Subject: FW: Stakers Farm, Y/105/19/PL & Y/106/19/L

Subject: RE: Stakers Farm

I have reviewed the revised plans dated which were passed to me on Monday and consider that they are an improvement on the previously submitted proposals. I note reference is made to the interior of barn one and think that it is helpful to finally have more of an understanding as to the proposals. The repurposing of the flint flooring is acceptable and details of how it is to be used within the site will be required. Could this be achieved by way of condition?

Proposed Section

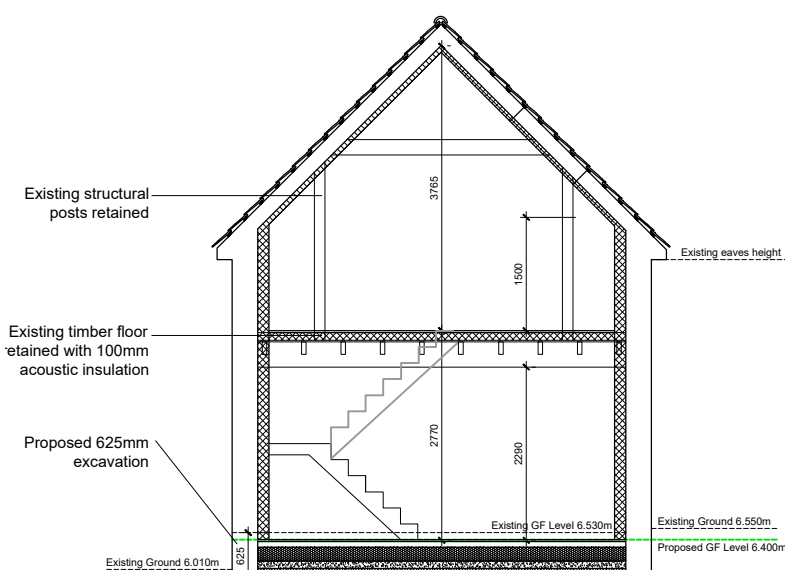
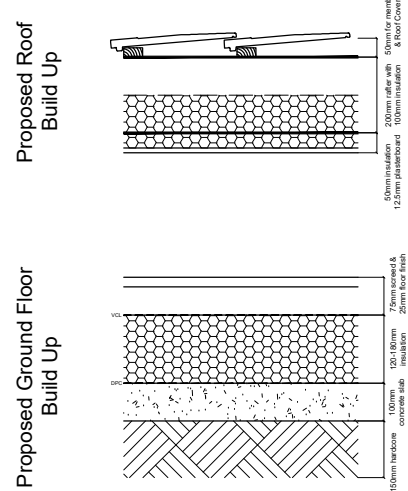
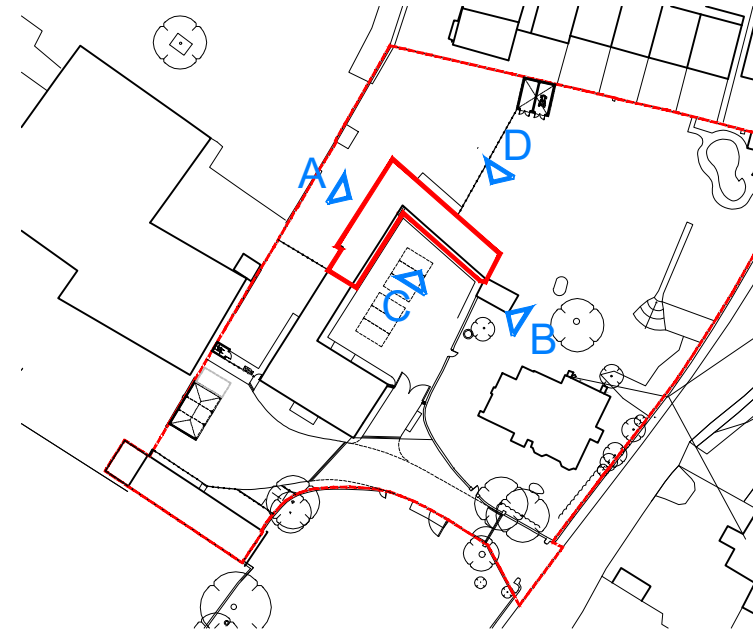
However, I am still concerned regarding the proposals for the walling and the timber ceiling/first floor which are important features of the space, especially in the ground floor area. As such, they should be retained. It could be that some of the walls remain as exposed brick, whilst others are covered with appropriate plaster. Details would need to be provided.

Likewise, as the agent states, the existing timber first floor could be retained as a feature on the ground floor space with new insulation and floor finishes dressed on top in the first-floor area. Further details in this regard can be addressed pursuant to a condition.

Proposed North-West Elevation (A)

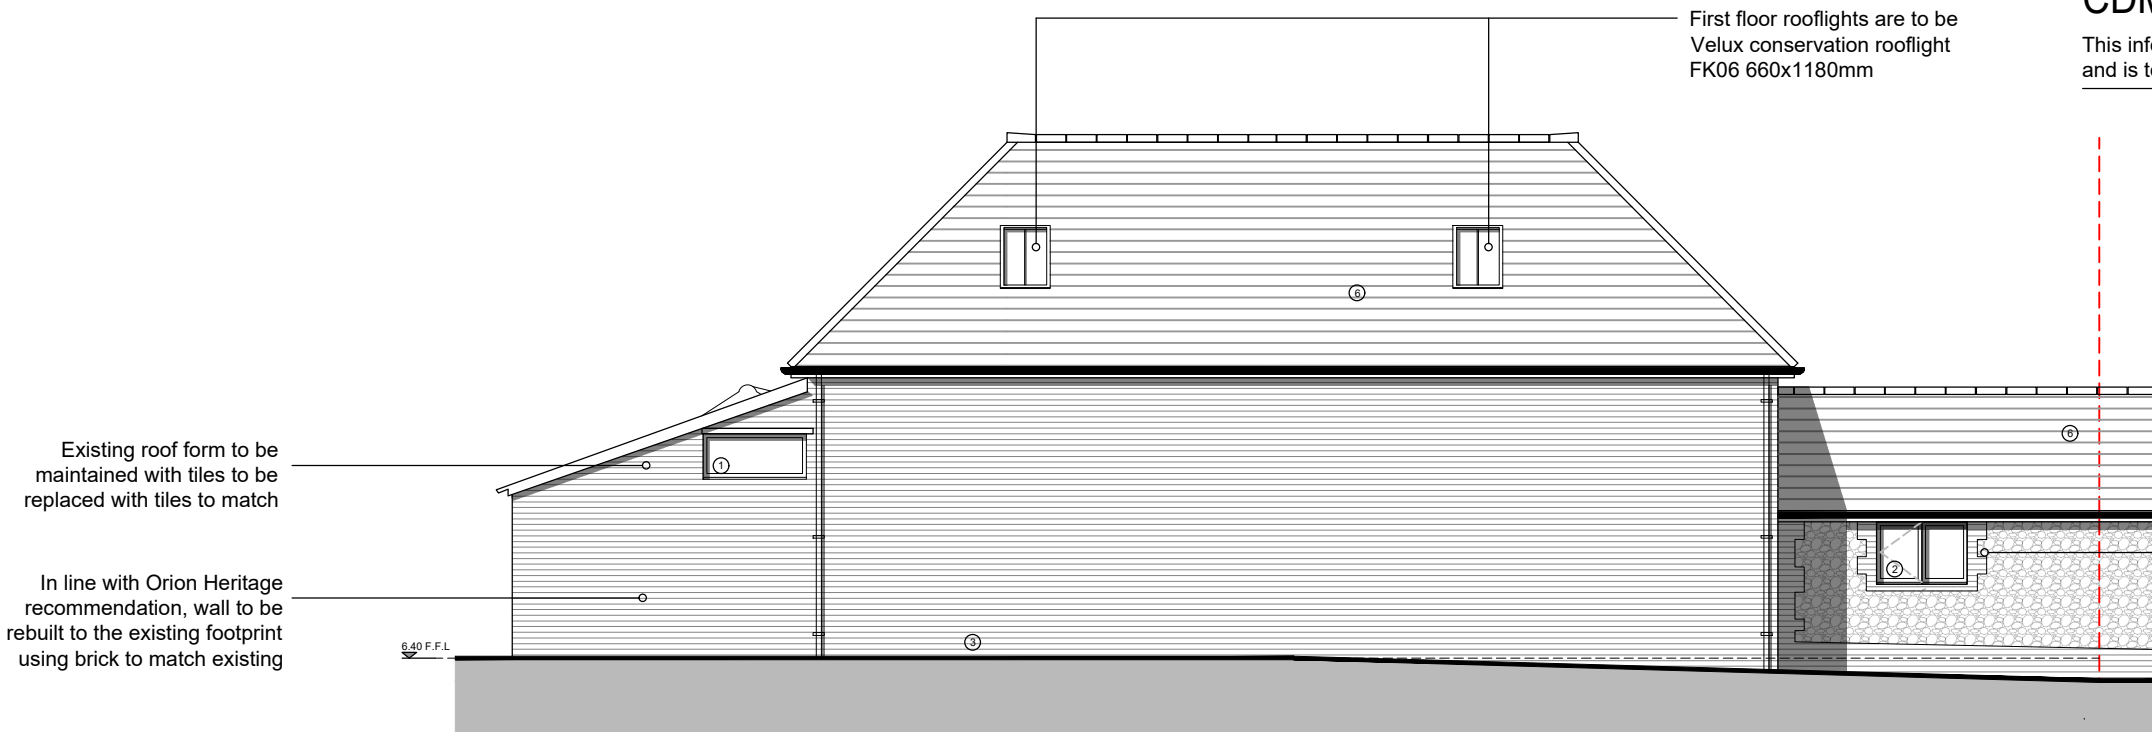
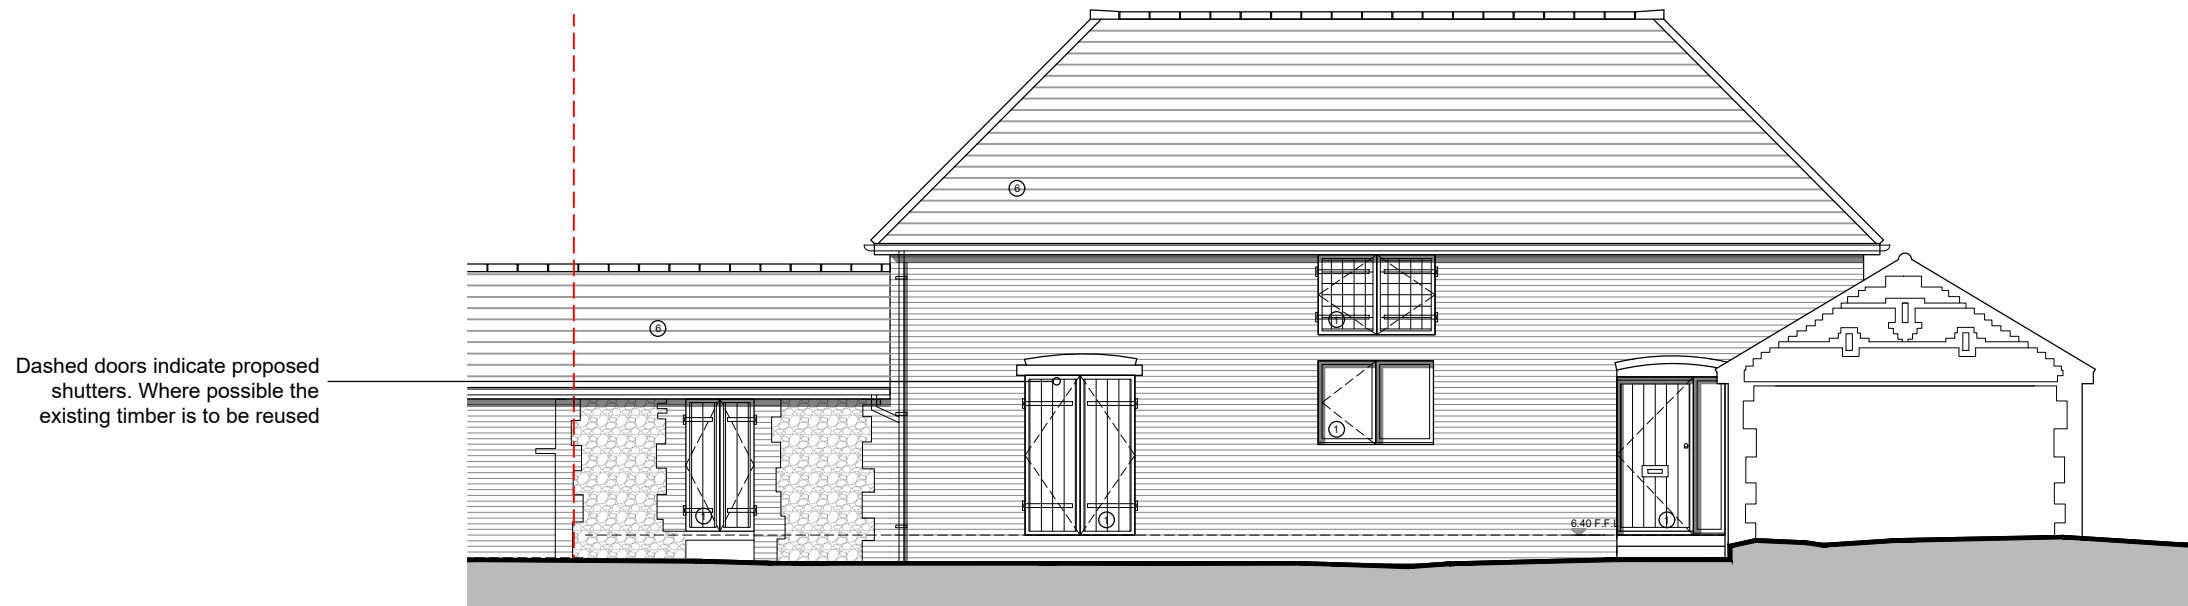
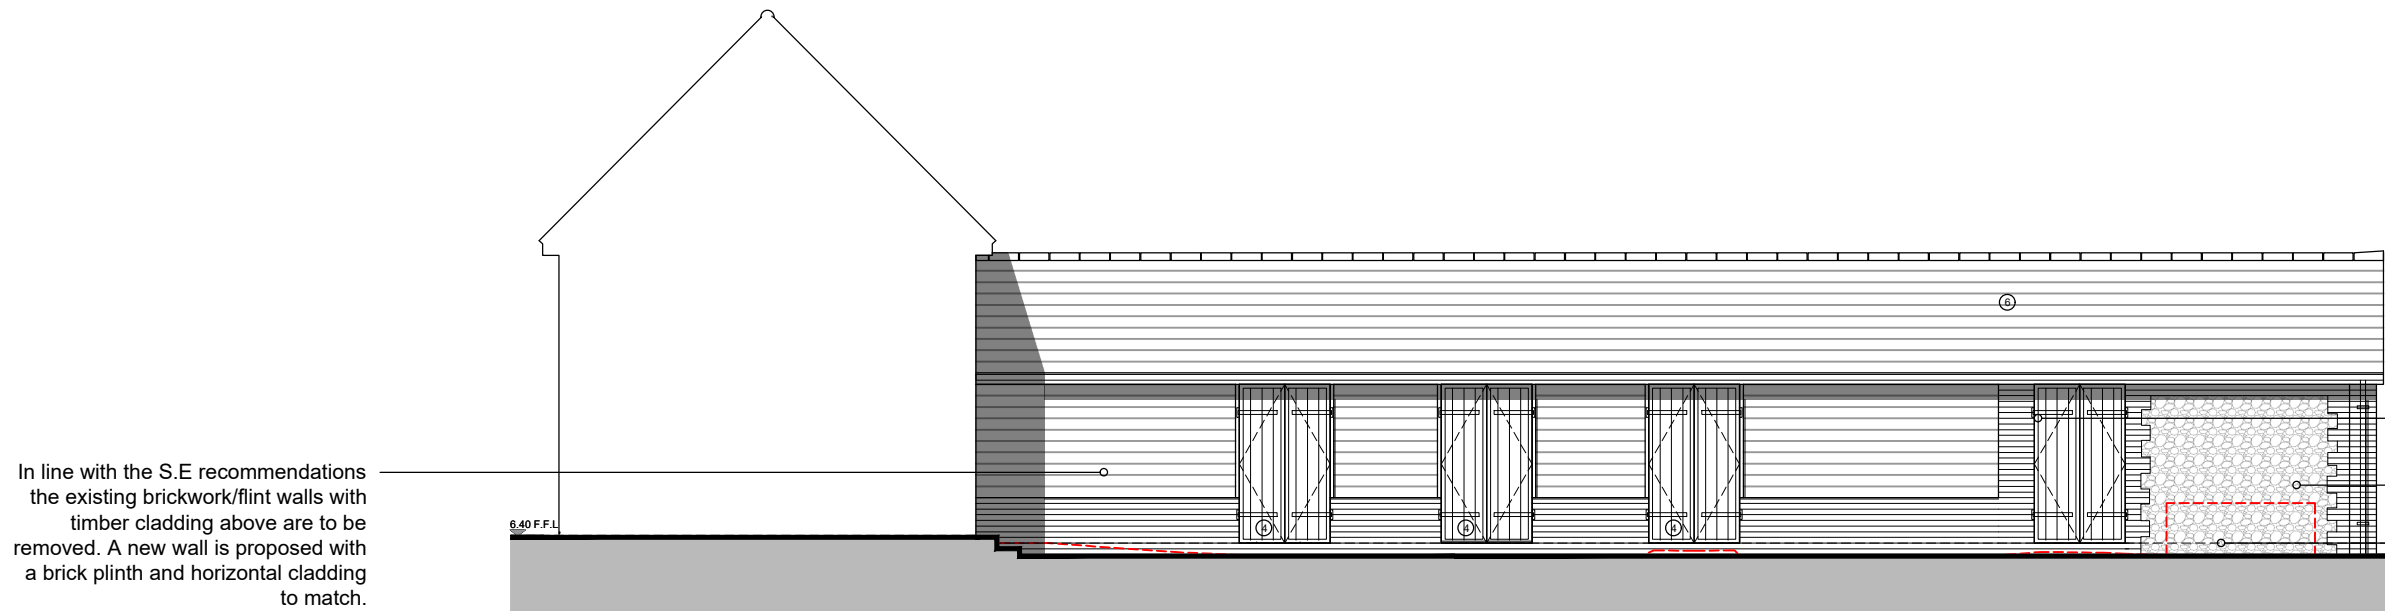
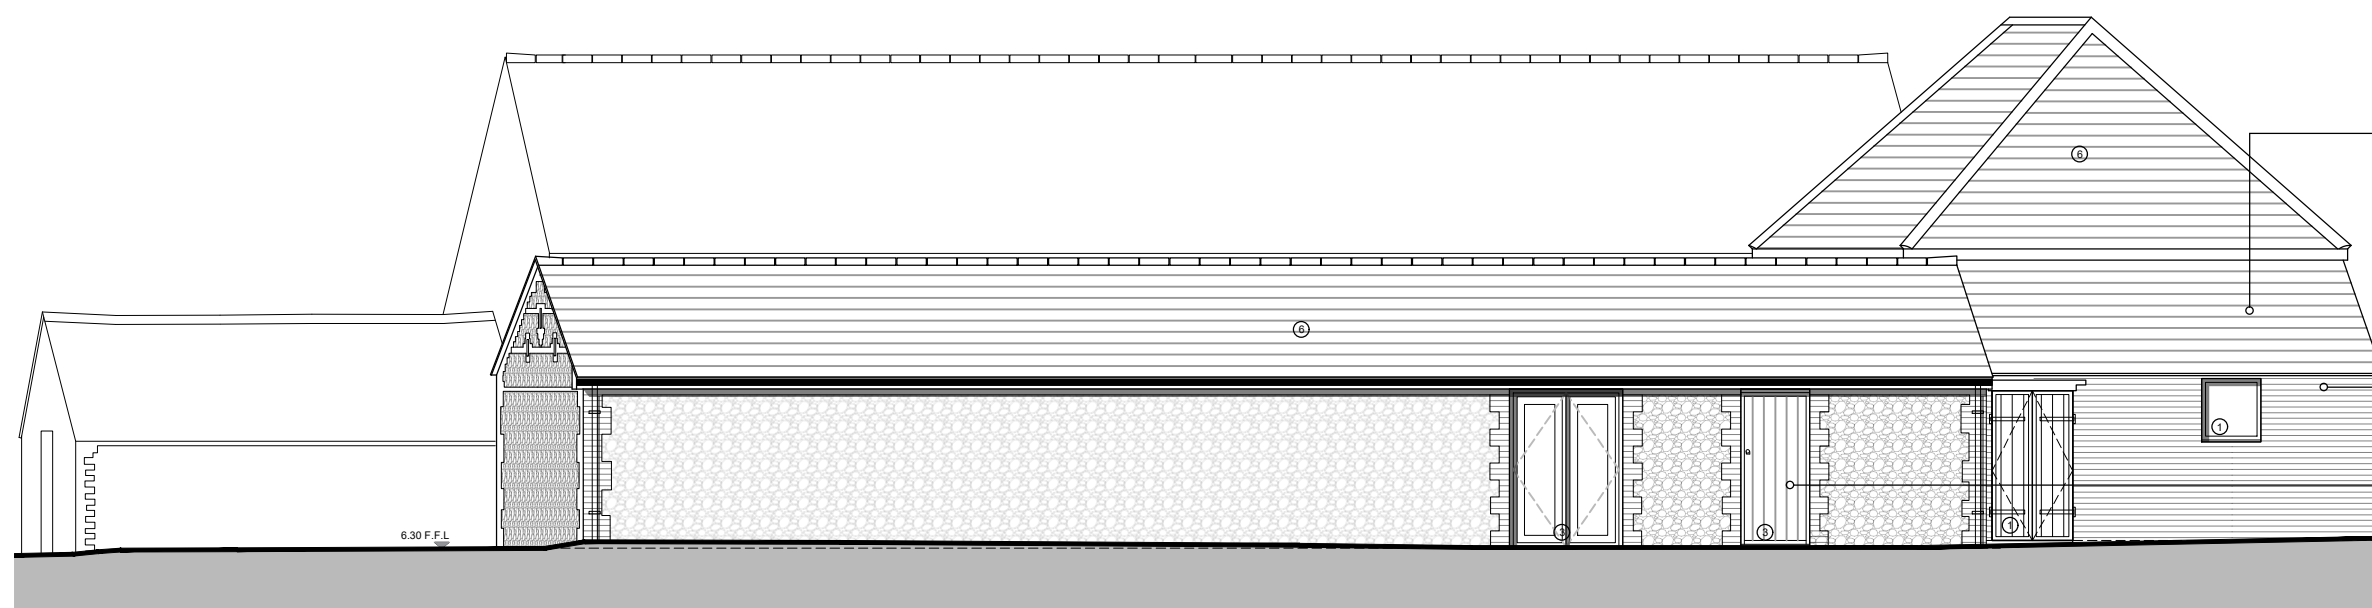
The success of such a scheme will depend upon the quality of the materials used, and landscaping etc as well as minor design details such as the position of the windows and doors in their openings (as indicated on the plans). Such materials and details can be conditioned if the application is to be recommended for approval.
